WELWYN HATFIELD BOROUGH COUNCIL – ESTATE MANAGEMENT SCHEME
DELEGATED REPORT

APPLICATION No:	W6/2013/2246/EM
APPLICATION Site:	7 Densley Close

The proposal seeks estate management consent for the demolition of existing side extension and replacement single storey side extension, along with alterations to the roof and windows at single storey level.

GROUND FLOOR PLAN

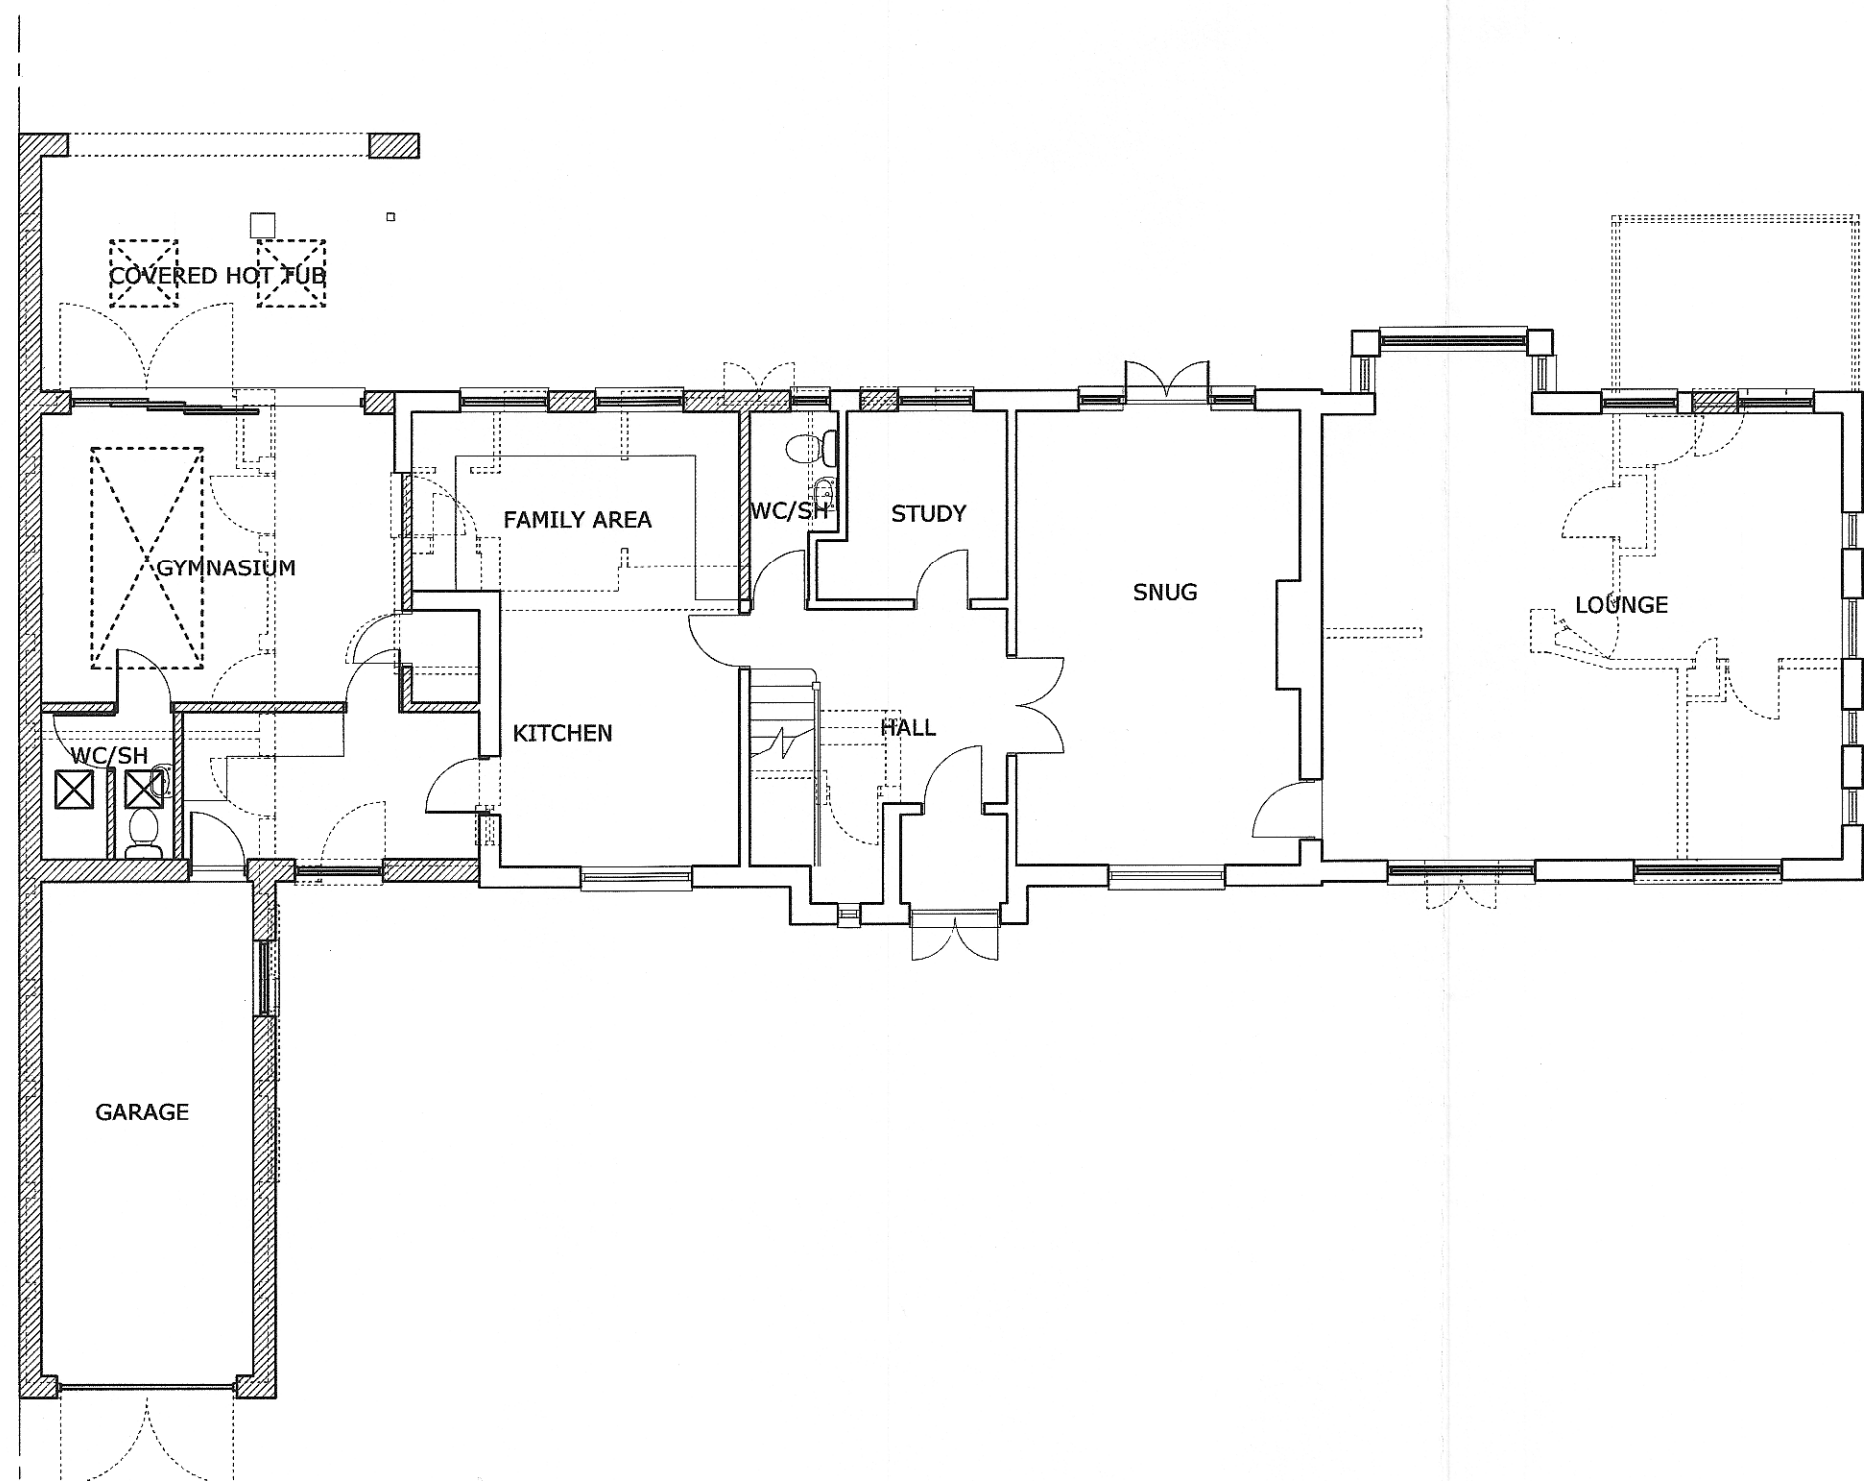
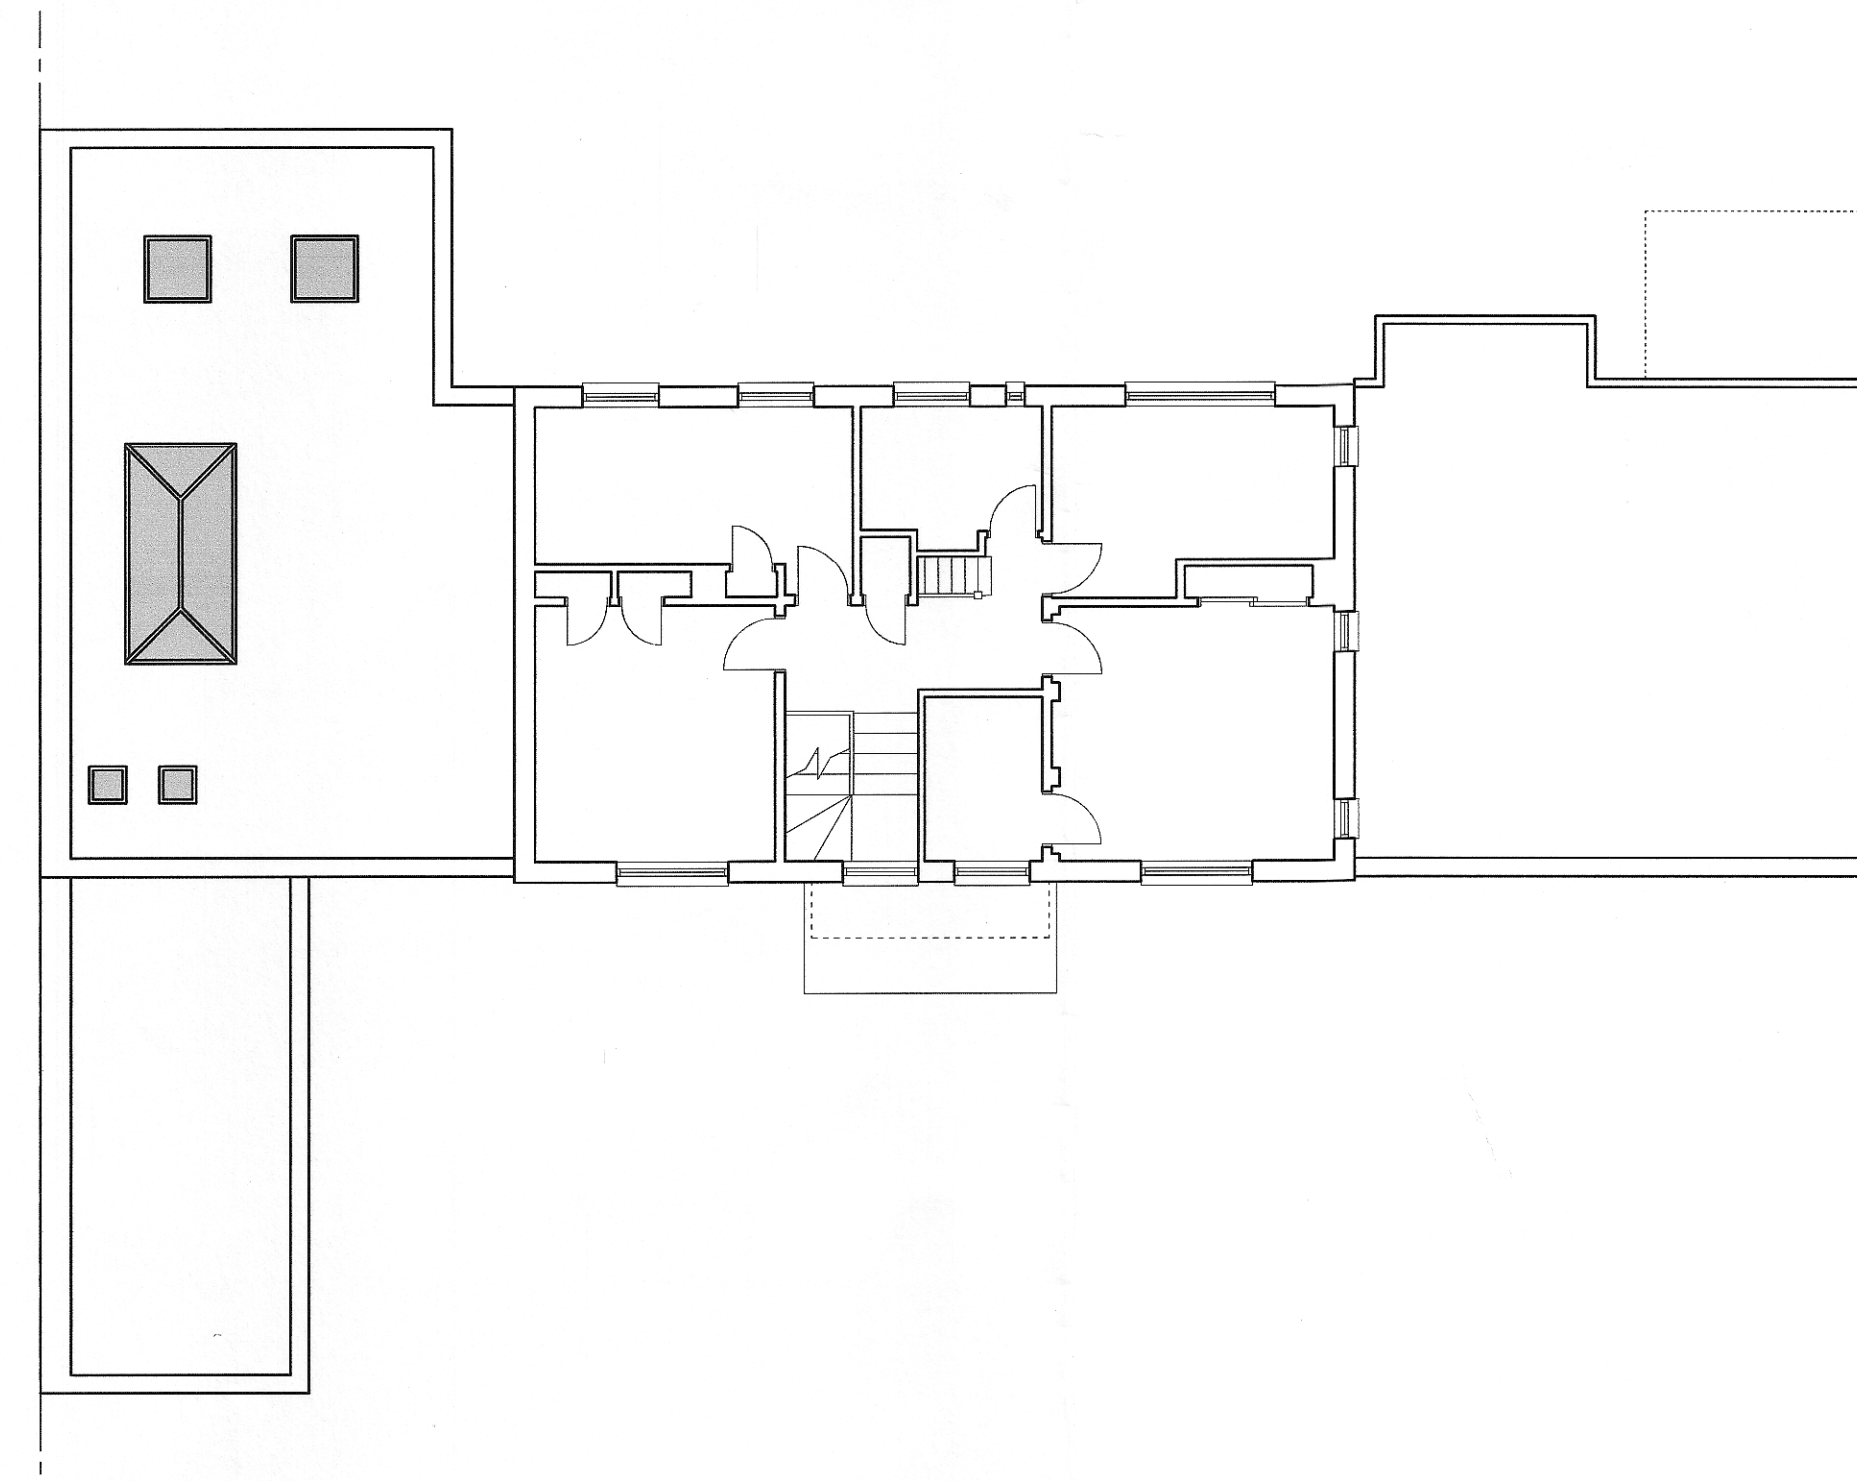
The proposal seeks to replace the existing single storey side extension along the northern elevation with a single storey side extension increasing the height of the extension to a maximum 3.25m and increasing the depth at the rear by a further 1m. Furthermore, the existing single storey extension attached to the southern elevation will increase in height by a further 0.2m. The proposal differs from that previously refused under estate management application, ref: W6/2013/1279/EM, by virtue of the northern elevation extension being reduced in height by 0.35m and the southern elevation extension being reduced in height by approximately 0.35m. The proposal was refused by virtue of the height of the parapet wall being near to the height of the first floor window sills which would appear stark and over dominant within the streetscene.

It is considered that the proposal has been sufficiently reduced in height to reduce the overall bulk and would more in keeping with the height of the parapet walls which exist within the streetscene. Furthermore, the proposal would incorporate coping stone as the parapet finish. The rooflights proposed on the northern side extension will not be visible within the streetscene and has been confirmed through an email from the agent, dated 10 December 2013. It would also be appropriate for condition the application for samples of materials to be submitted prior to commencement of development to ensure the materials appropriately match the existing dwellinghouse.

The properties most impacted by the proposal are neighbouring properties, No. 5 Densley Close to the north and No.19 Scholars Mews to the south. The existing garage is attached to the neighbouring single storey side extension at No.5 Densley Close. The existing garage already extends further beyond the rear of No.5 by approximately 1m with the proposed replacement side extension resulting in approximately 2m extension beyond the rear of No.5. Windows exist on the rear of No.5 in close proximity to the proposed extension however a 2m extension is not considered to result in an unduly dominant feature when viewed from these windows. Furthermore, the proposal is not considered to detrimentally impact upon loss of sunlight/daylight skylight when compared to the existing extension taking into consideration the extension will only extend a further 1m in depth and the orientation of No.5 to the north east of the application dwelling where a limited amount of light reaches these windows during large parts of the day.

The proposed height increase of 0.2m to the existing single storey side extension extending beyond the southern elevation is considered sufficient distance from No.19 Scholars Mews (approximately 10m) not to detrimentally impact upon loss of sunlight/daylight. The existing side windows are being retained with the floor level increase internally of approximately 15cm. However, the existing window openings and siting are not being altered and therefore the proposal is not considered to result in any further overlooking/loss of privacy to neighbouring properties when compared with the existing situation.

6. The development/works shall not be started and completed other than in accordance with the approved plans and details: 3018-OS1 & 3081-OS2 Rev A received and dated 24 October 2013 & 3018-P01 Rev C received and dated 11 December 2013
